From: Simon Davis
Sent: 18 May 2020 17:49
To: Jack Dowling [REDACTED]
Subject: RE: BR/55/20/PL

Proposed Ground Floor Plan

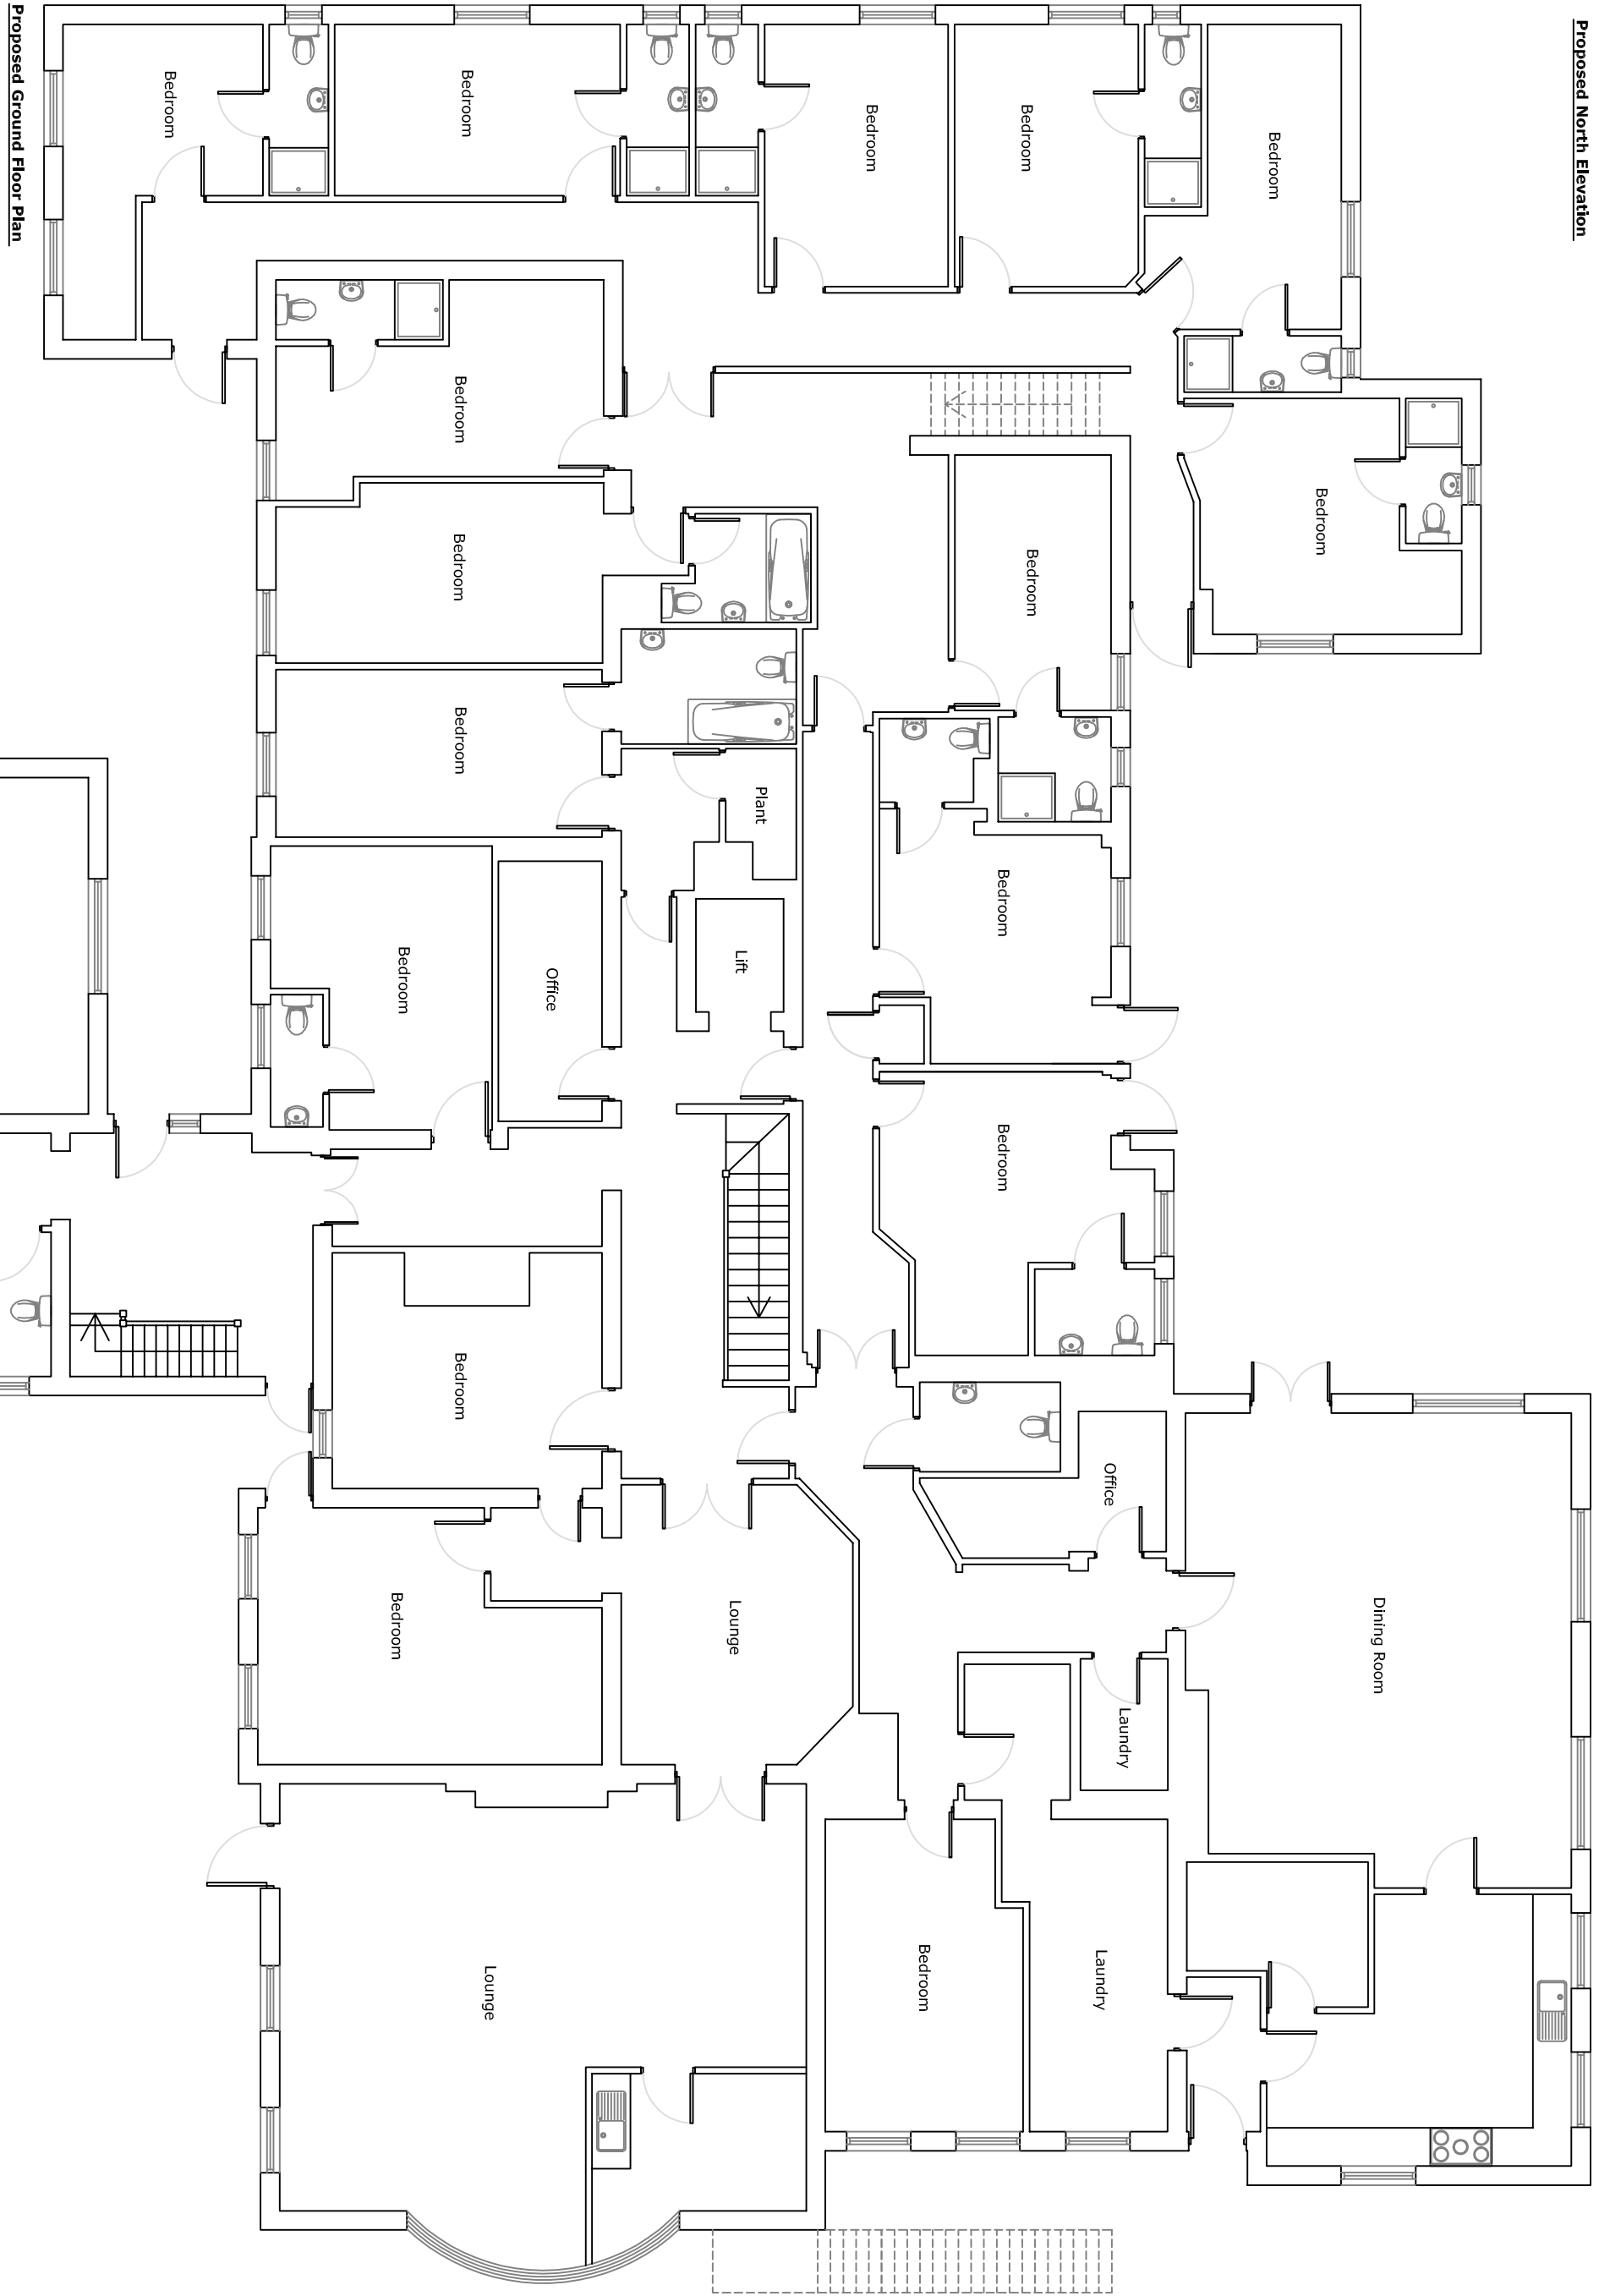
I note that on BR/134/17/PL there were changes shown to the access (widening) and the parking area with a minibus space shown where you now show two the new parking spaces. Also changes to the fence line & bin store. Can you advise why these changes are no longer required. I note that these changes were welcomed by Highways at the time.

I do not want to formally accept the revised parking plan until there is clarification on the above matters.

Please find attached as discussed, we can confirm that no extra staff will be employed, we have now added 2 extra spaces albeit that the only extra parking if any will be used by visitors, this will also have no detrimental affect on the existing situation as visitor times are staggered at the home as per health and safety legislation
